OFFICIAL NOTIFICATION OF DECISION

Project# PR-2021-005426
Application#
SI-2021-00185 EPC SITE PLAN FINAL SIGN-OFF

All or a portion of **LOT J, COLES INDUSTRIAL NO. 2** zoned **NR-SU**, located at **3300 VASSAR DR NE** between **CANDELARIA RD NE** and **AZTEC RD NE** containing approximately **0.3903** acre (**G-16**)

**CARE CENTER (MORTUARY & CREMATORIUM)
3300 VASSAR DRIVE NE
SITE PLAN**

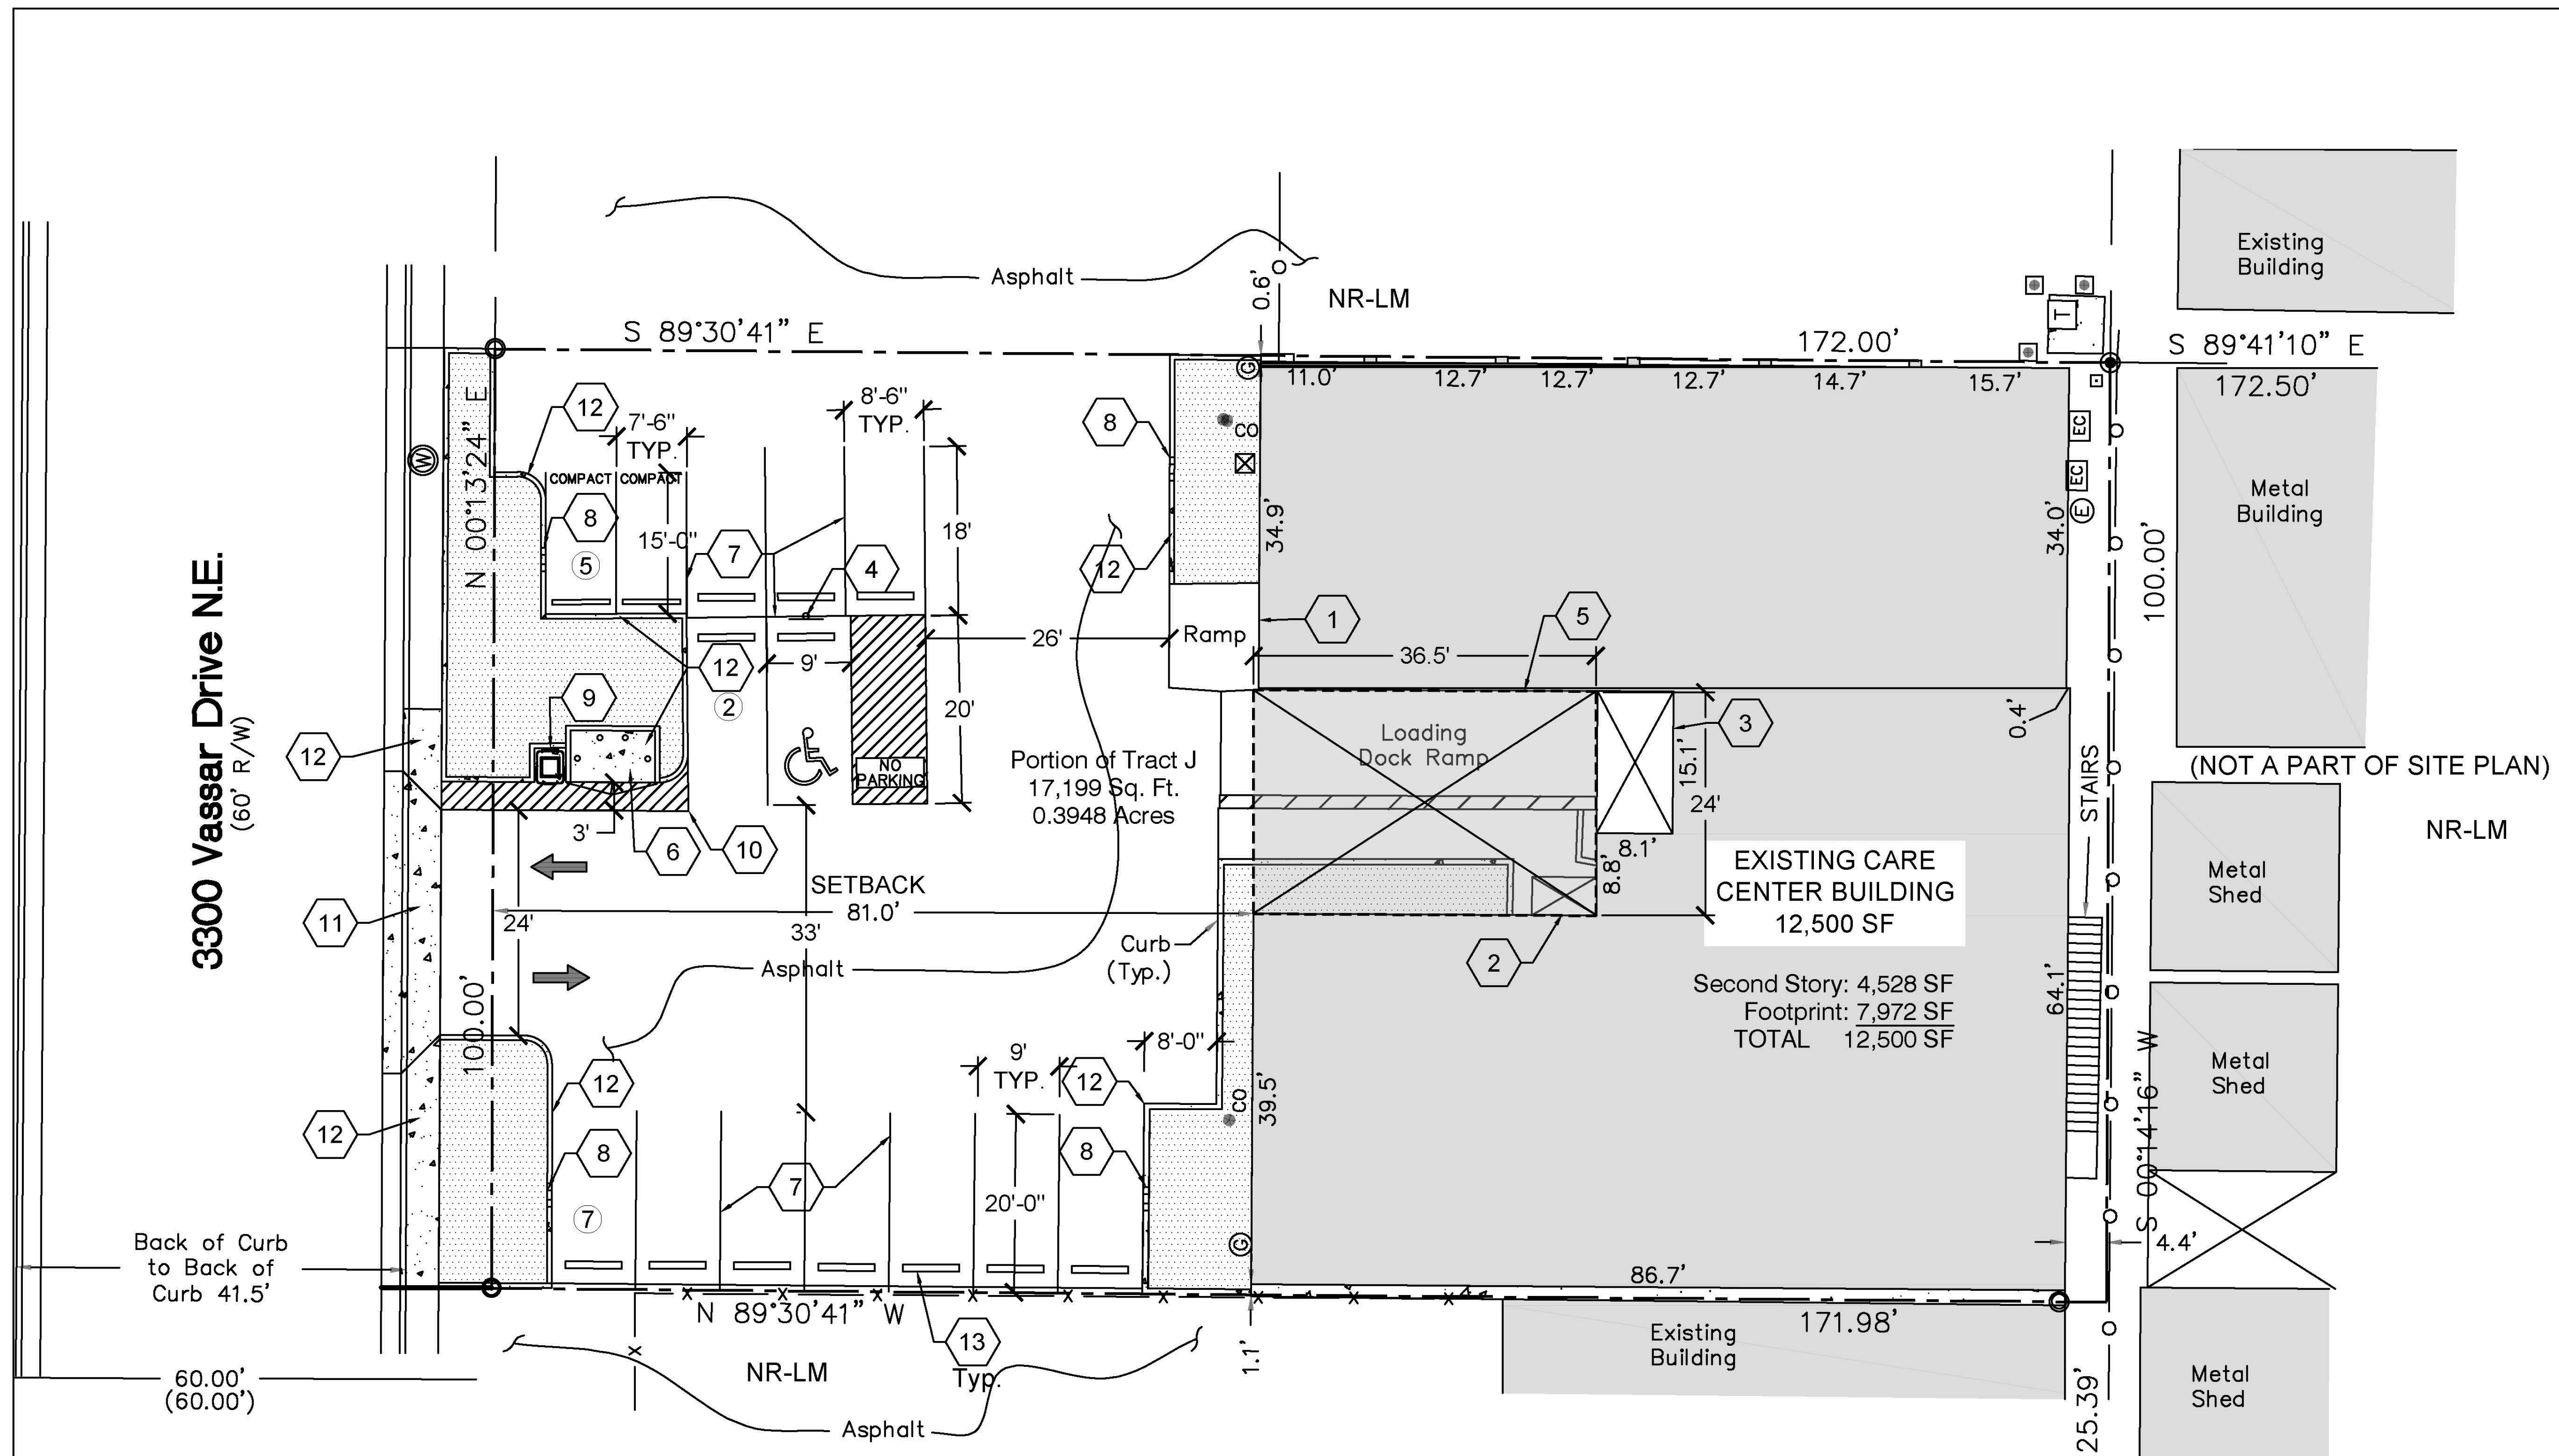
1. Final sign-off is delegated to Transportation regarding an ADA compliant driveway within the ROW, for the replacement of any cracked sidewalk, to designate striping and signage related to ADA requirements, show clear site triangles, and for the use of keyed notes to call out curb and other infrastructure.

CARE CENTER (MORTUARY & CREMATORIUM)
3300 VASSAR DRIVE NE
LANDSCAPE PLAN

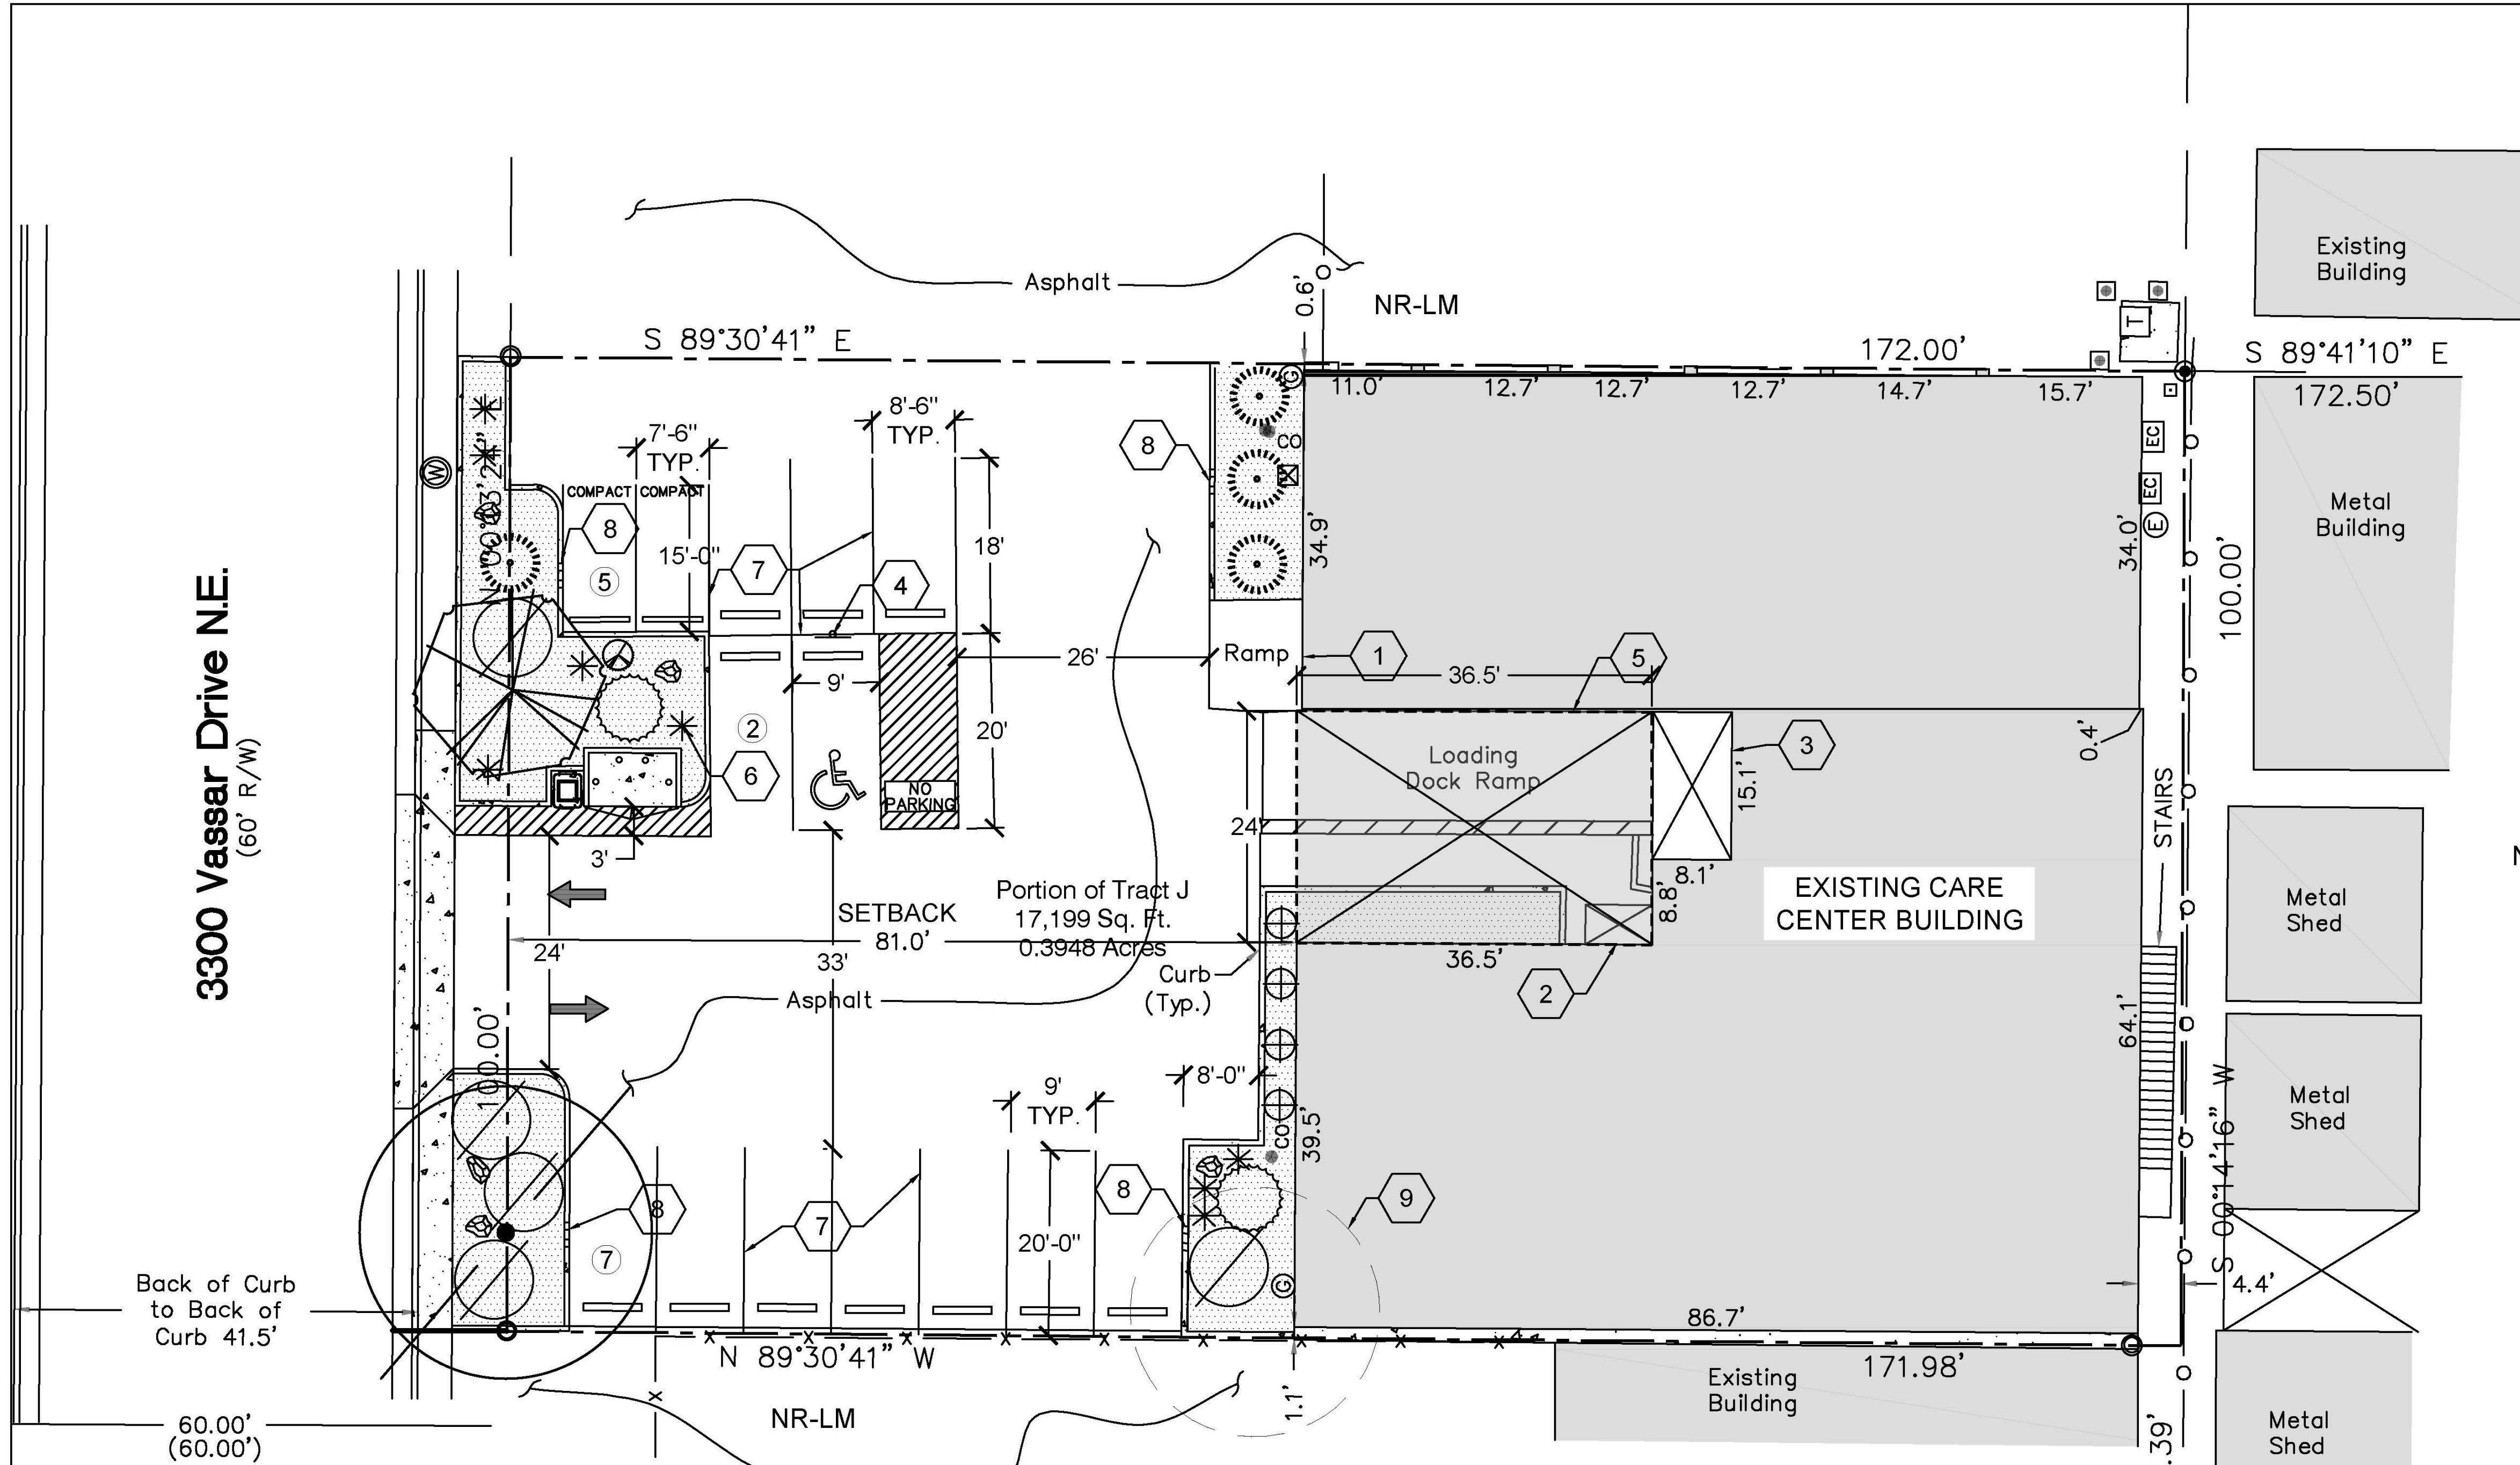
2. Final sign-off is delegated to Planning for a note for organic mulch under trees per IDO 5-6(C)5(e), the solid waste signature, and for the application number to be added to the Site Plan.
3. The applicant will obtain final sign off from Transportation and Planning by May 4, 2022 or the case may be scheduled for the next DRB hearing and could be denied per the DRB Rules of Procedure.
